REF: N147950

DATE: 27 February 2020

**RE: MEADOWBANK EDUCATION AND EMPLOYMENT PRECINCT SCHOOLS PROJECT – SSD
18_9343 RESPONSE TO TRANSPORT RELATED SUBMISSIONS**

Response to Submissions

APPROVED BY
B.MAYNARD

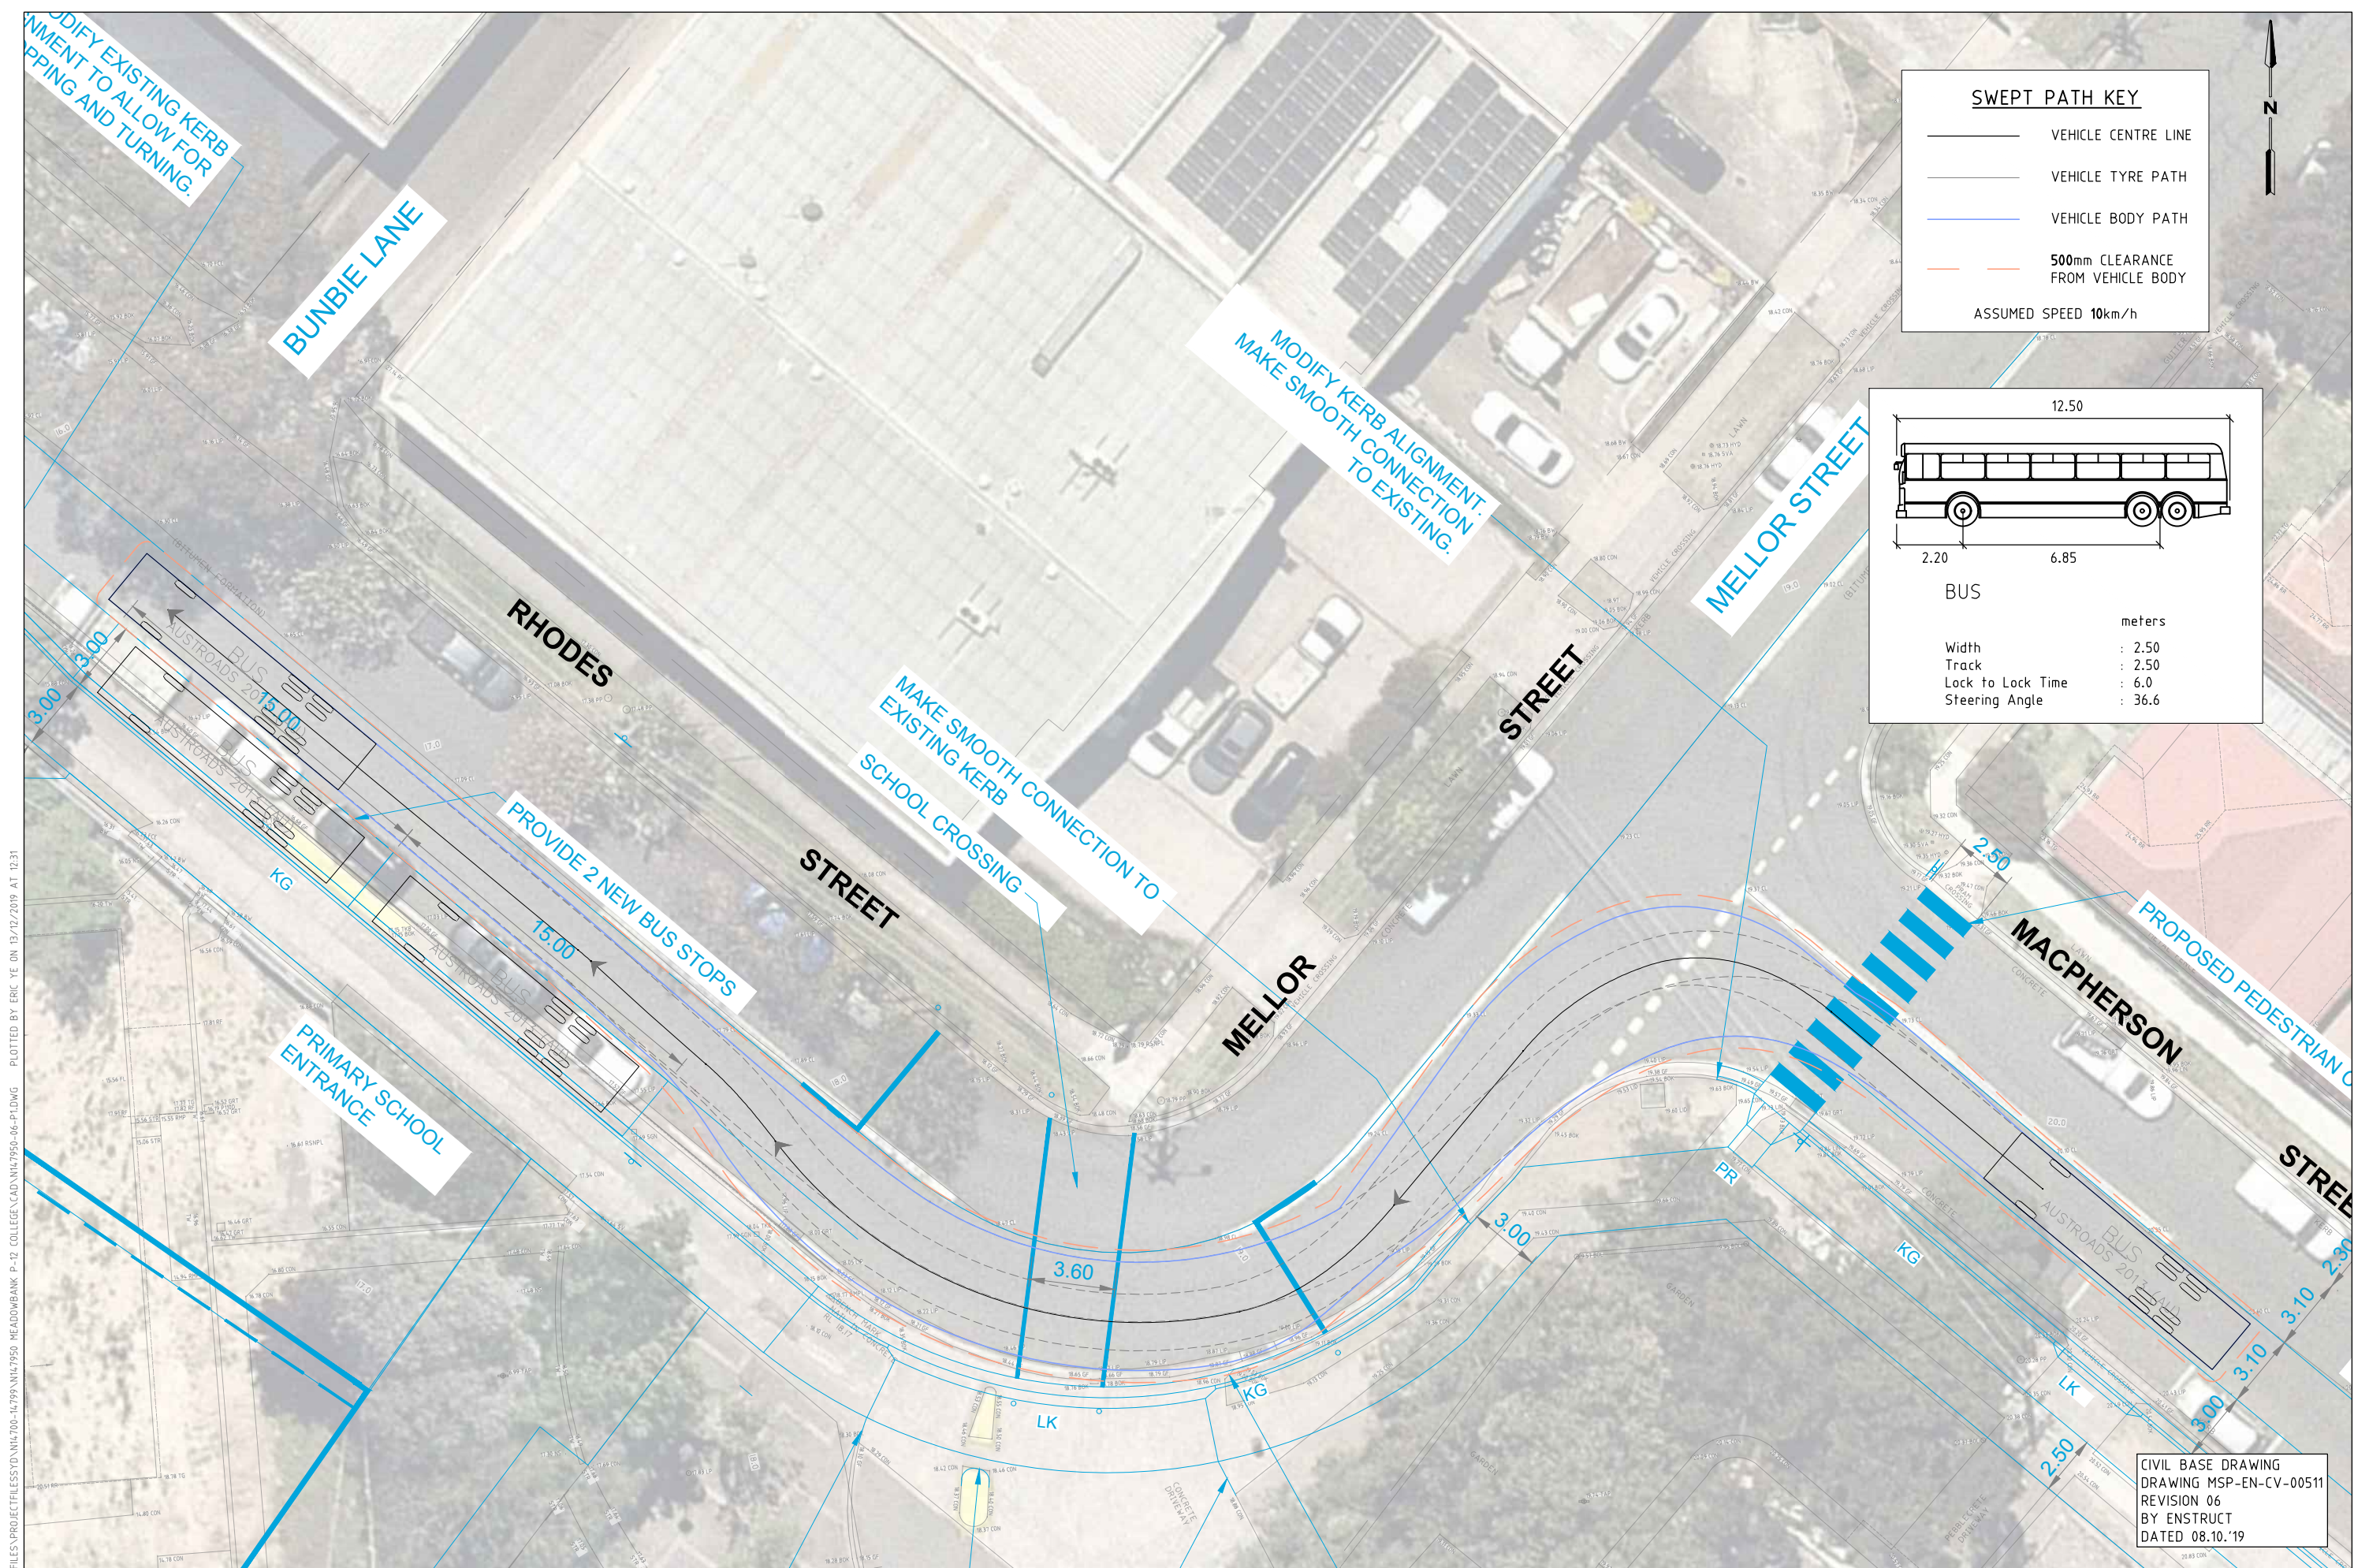
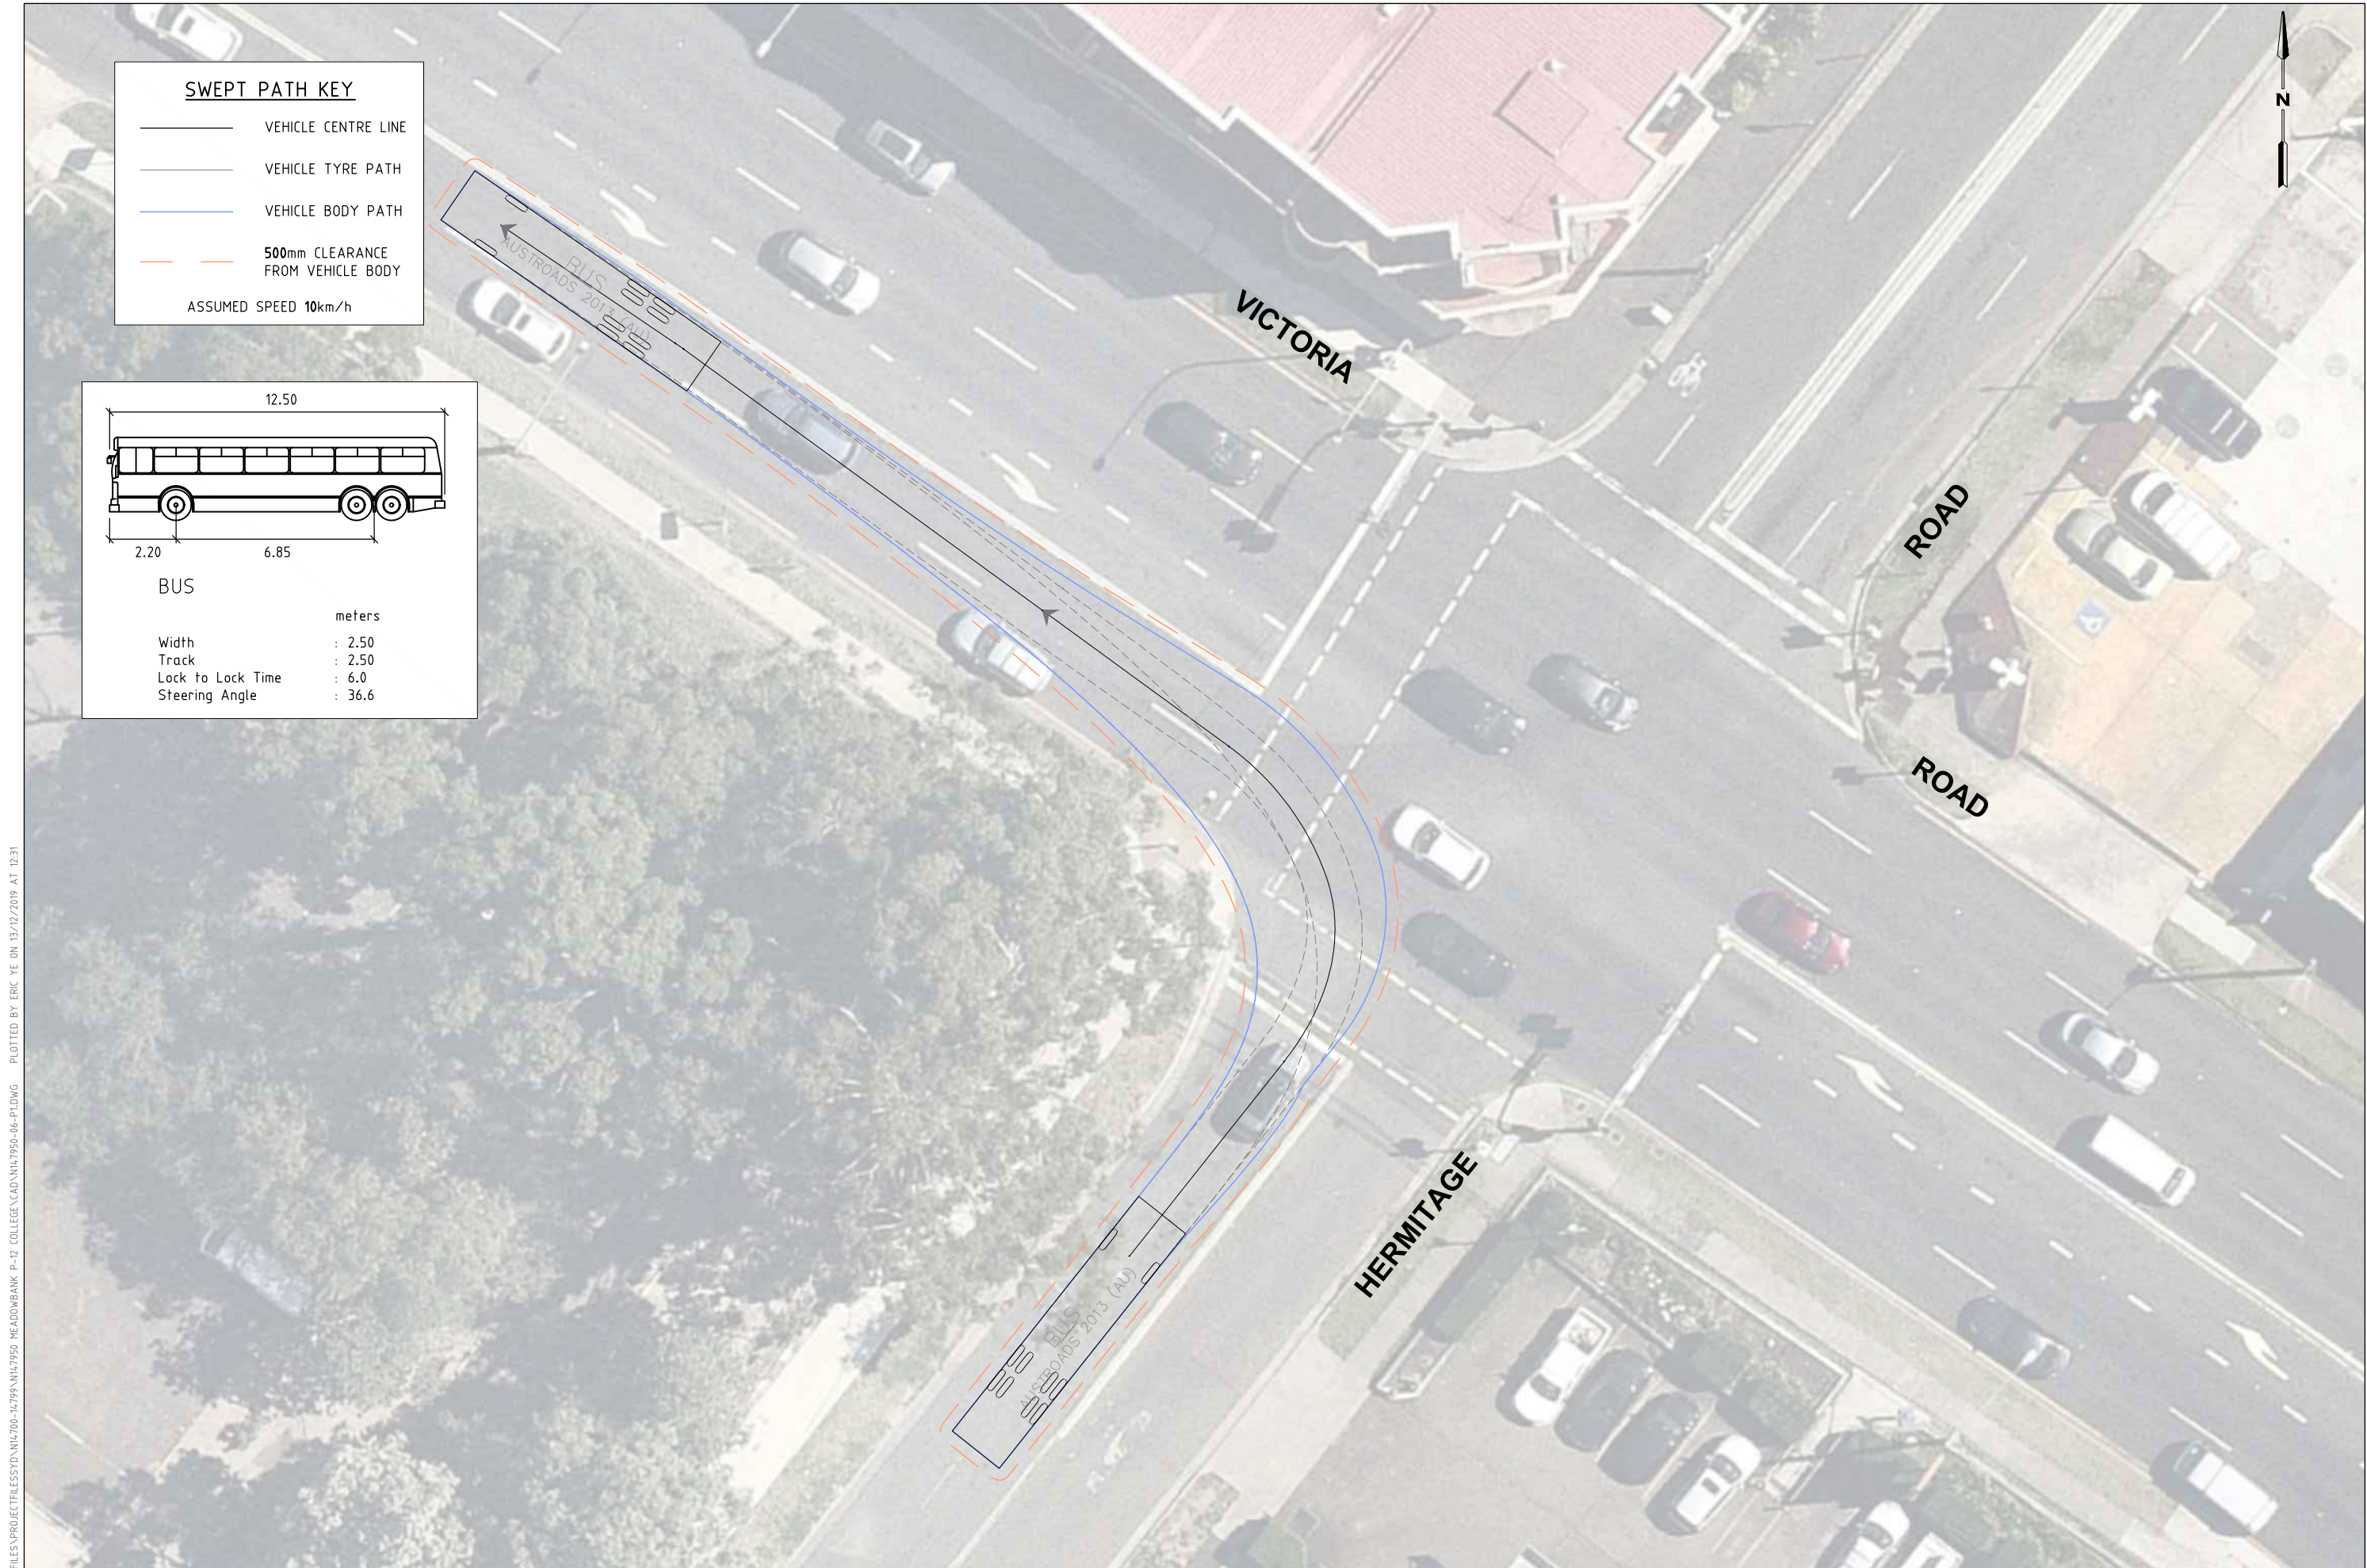
Comment 1: Swept path analysis should be provided for buses on all streets between Victoria Road and the proposed bus zone locations to ensure the surrounding streets are capable of accommodating the future school bus services. Turnaround facility on Rhodes Street with access for all services via Hermitage Road should also be considered to better facilitate the future traffic generating from the school sites. The proposed length and allocation to Primary school of a bus zone on Rhodes Street should also be further reviewed for servicing the proposed two school bus stops. Clarification should also be provided on how the works will be delivered.

GTA response: A swept path assessment has been completed for the likely 12.5 metre bus on approach and departure between the site and Victoria Road and shown in Attachment 2. It is noted that the proposed bus route (particularly Rhodes Street and Hermitage Road) is already a heavy vehicle access route for the existing industrial area.
